**Laurie Leader - FW: BP#2014-02379 299 Presumpscot Street - Plan review comments**

**From:** "Thomas Blackburn" <teb@portland.twcbc.com>  
**To:** "laurie leader" <lrl@portlandmaine.gov>  
**Date:** 10/31/2014 2:07 PM  
**Subject:** FW: BP#2014-02379 299 Presumpscot Street - Plan review comments  
**CC:** "Ryan Senatore" <ryan@senatorearchitecture.com>  
**Attachments:** 1428 - Grime Studios - 299 Presumpscot - Code review copy.pdf; ATT00057.htm

**From:** Ryan Senatore [mailto:ryan@senatorearchitecture.com]  
**Sent:** Friday, October 31, 2014 12:33 PM  
**To:** Thomas Blackburn  
**Cc:** justin curtsinger  
**Subject:** Re: BP#2014-02379 299 Presumpscot Street - Plan review comments

WALL SECTION AT FLOOR AND CEILING

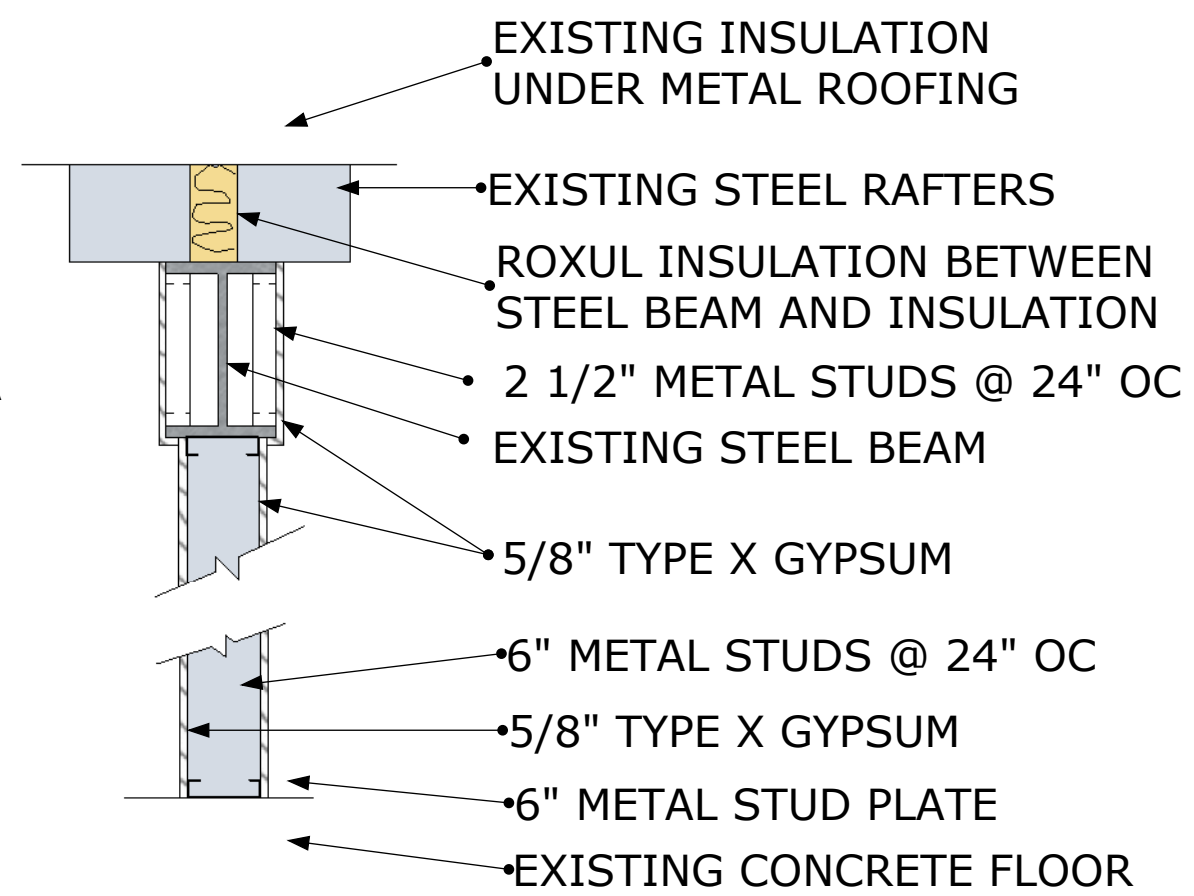
- 2.
3. Given the new partition layout, you provide new wall partitions but there is no detail regarding the ceilings of these new partitions. Please provide clarification and details on the ceilings of the rehearsal areas.

Good afternoon Laurie, please see the attachments and language below in response to your questions. The ceiling will be suspended with acoustical tile upon which will be added 6" of either roxul insulation or an equivalent fiberglass with similar acoustical properties. I hope this answers your questions Thanks TEB

CODE ANALYSIS

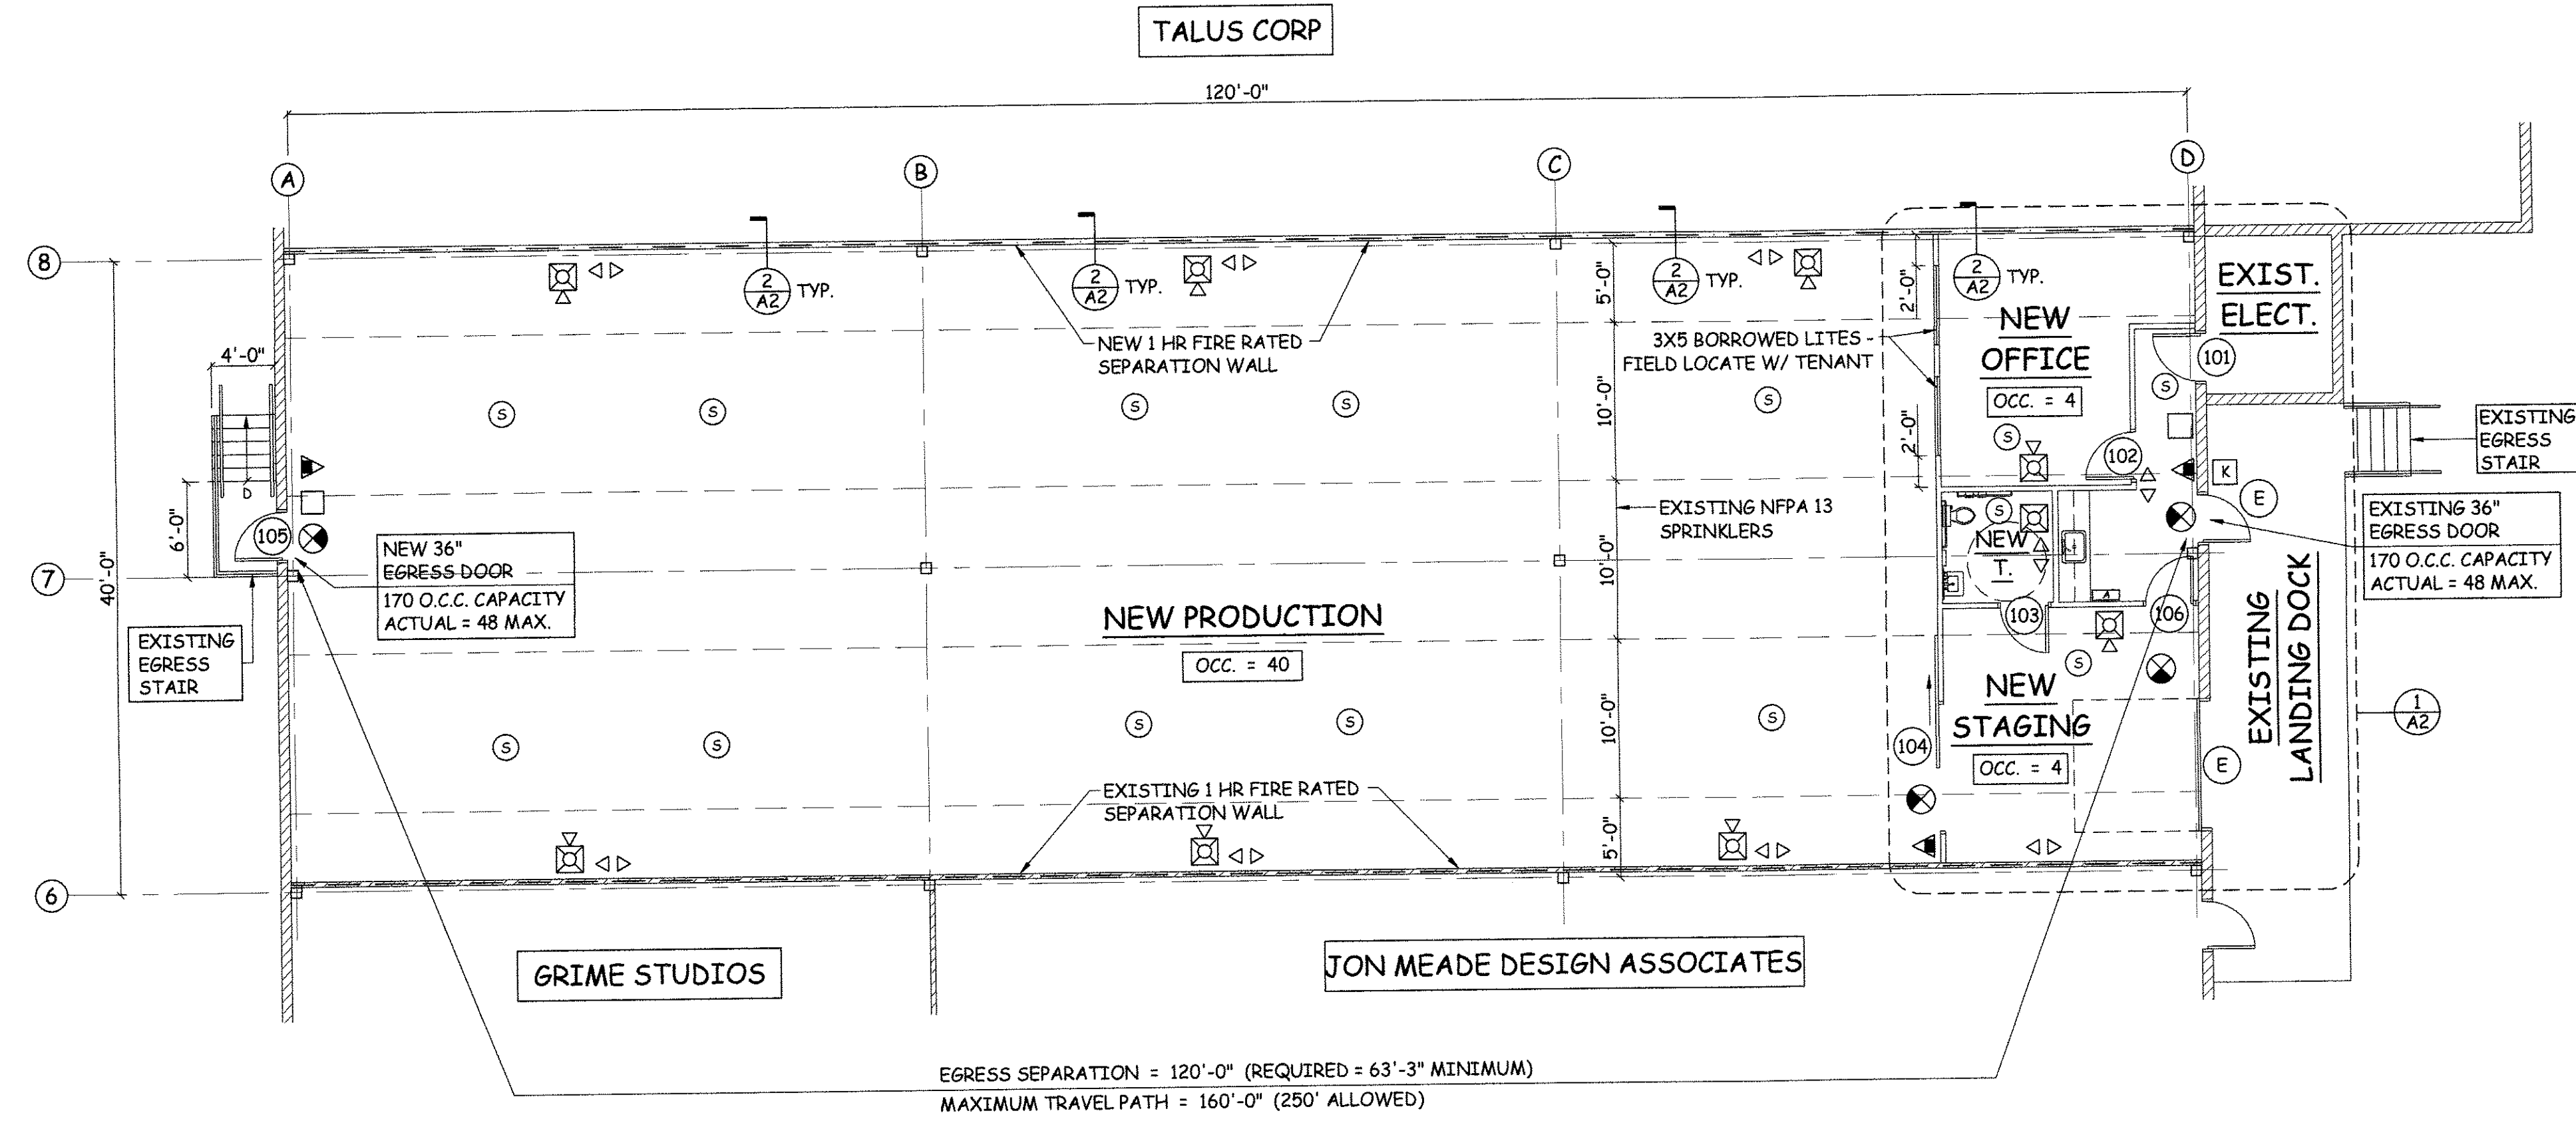
1. Per section 505.2 and given the new floor plan layout, the area now referred to as mezzanine no longer qualifies as a mezzanine. Can you please revise the code analysis to indicate this change? (Per the code, this would be a story rather than mezzanine.)

- 1.
2. Provide occupant load given the option you use for the second story (Offices have an occupant load of 100 gross where as if this was a break room the occupant load would be calculated with 15 net) and verify if the egress distance and number of exits are allowed given the use.

Please see the attached Code Analysis revised to indicate the second story versus mezzanine designation

The occupant load for the second story is (787 sf) 8 occupants, this will be used as office space and not a break room thus we have used the 100 sf per occupant figure.
